**SYDNEY  
REGIONAL  
DEVELOPMENT  
ADVISORY  
COMMITTEE**

**SYDNEY FISH MARKET, BLACKWATTLE BAY, PYRMONT  
ENVIRONMENTAL ASSESSMENT**

I refer to the Department of Planning's letter dated 20 September 2010 (Reference: MP10\_0060), concerning the abovementioned development application which was referred to the Roads and Traffic Authority (RTA) for comment.

The Sydney Regional Development Advisory Committee (SRDAC) considered the traffic impact of this application at its meeting on 6 October 2010, and provides the following comments:

Intersection of Bank and Miller Streets Pyrmont

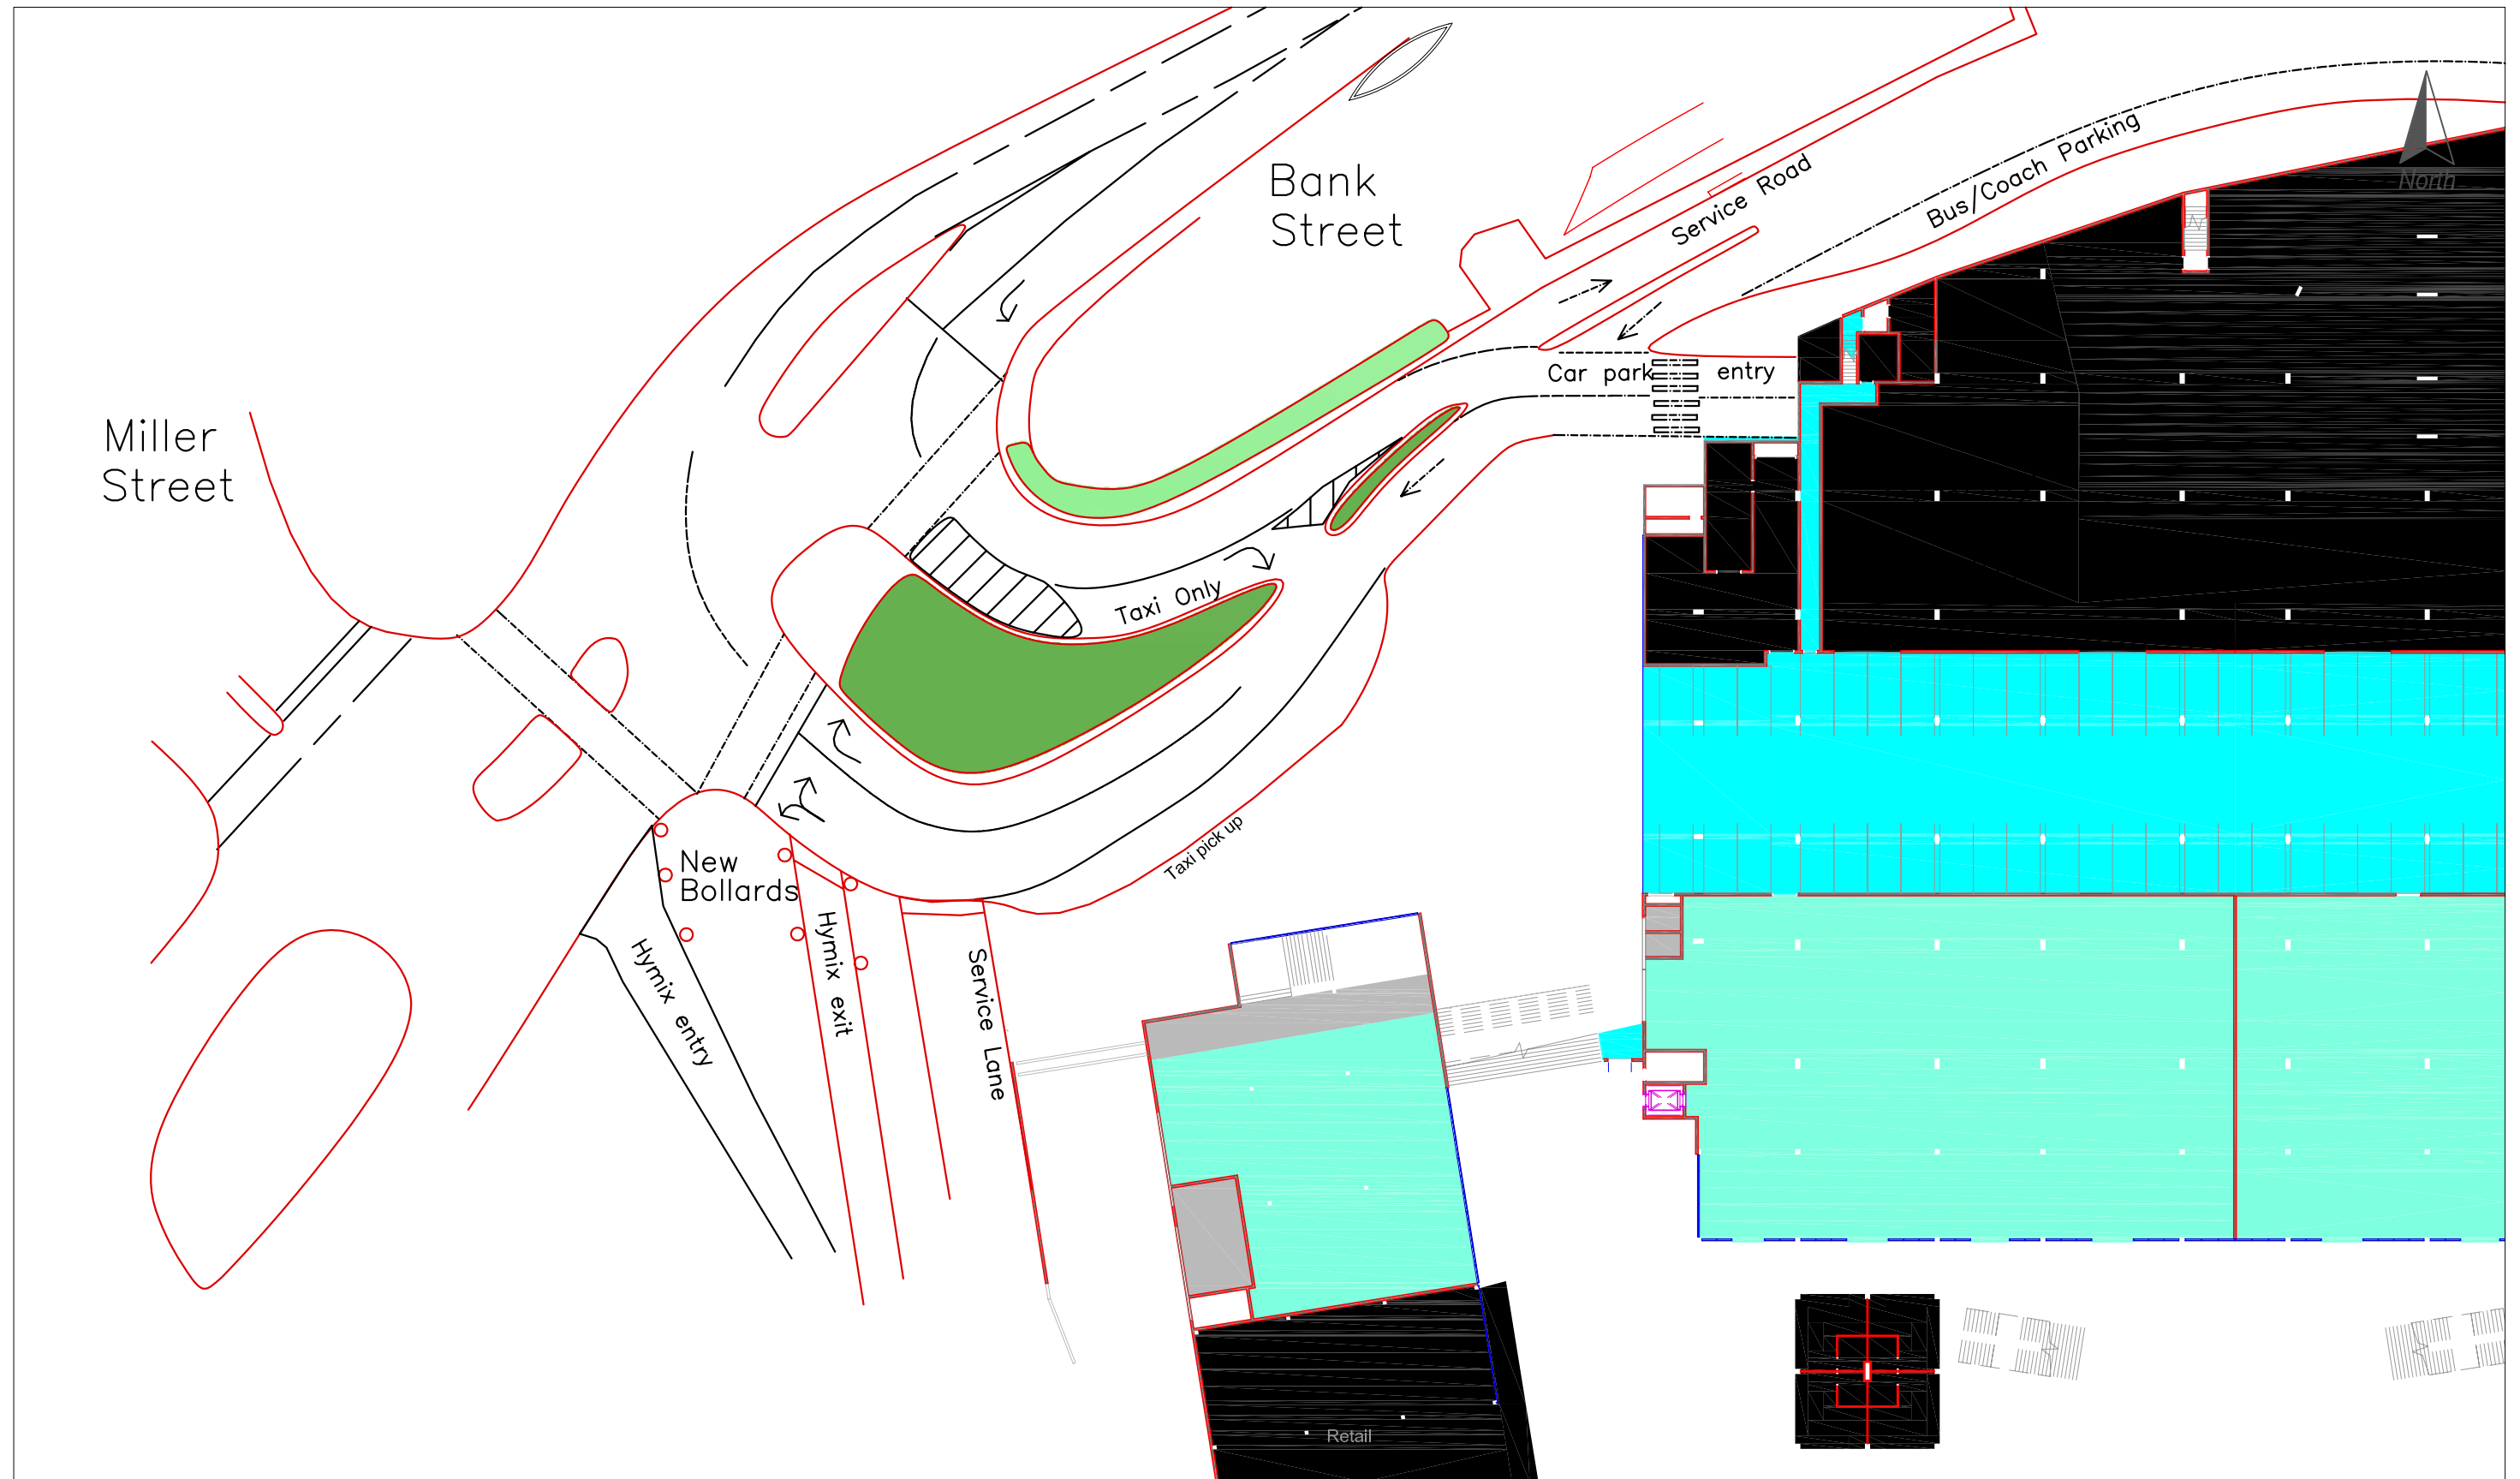
2. In regard to the revised intersection layout for the signalised intersection of Bank Street and Miller Street, the following concerns are raised:
  - The location of the modified Hymix concrete plant entry and exit and the service lane.

An independent Stage 2 Road Safety Audit shall be undertaken on the proposed Hymix concrete plant entry and exit and the proposed service lane, as illustrated on the concept signal design plan, by a certified auditor.

- The length of the proposed "A" phase pedestrian crossing is excessive. The current duration of the "A" phase pedestrian crossing is 23 seconds (walk and clearance), and would have to be increased significantly to cover the proposed crossing distance. This would result in reduced green time to all other signal phases.
- The re-positioning of the stop line in the proposed plan would cause an increase in red time for all other phases, therefore creating a less efficient traffic signal operation.

The developer should consider the provision of a slip lane for the westbound entrance into the site and the stop line to be left in its existing position.

- The turning curve on the exit approach from the site is excessively sharp. This will result in larger headways for vehicles exiting the fish markets, again causing inefficient traffic signal operation.

4. Consideration should be given to increasing the length of the divergence of the dual-lane approach to the signalised exit of the site at the intersection of Miller Street and Bank Street in order to increase the storage of the residual queuing of vehicles on-site.

Revised intersection plans which address the abovementioned concerns (including an electronic copy of the proposed signal phasing) shall be submitted to the RTA for approval.
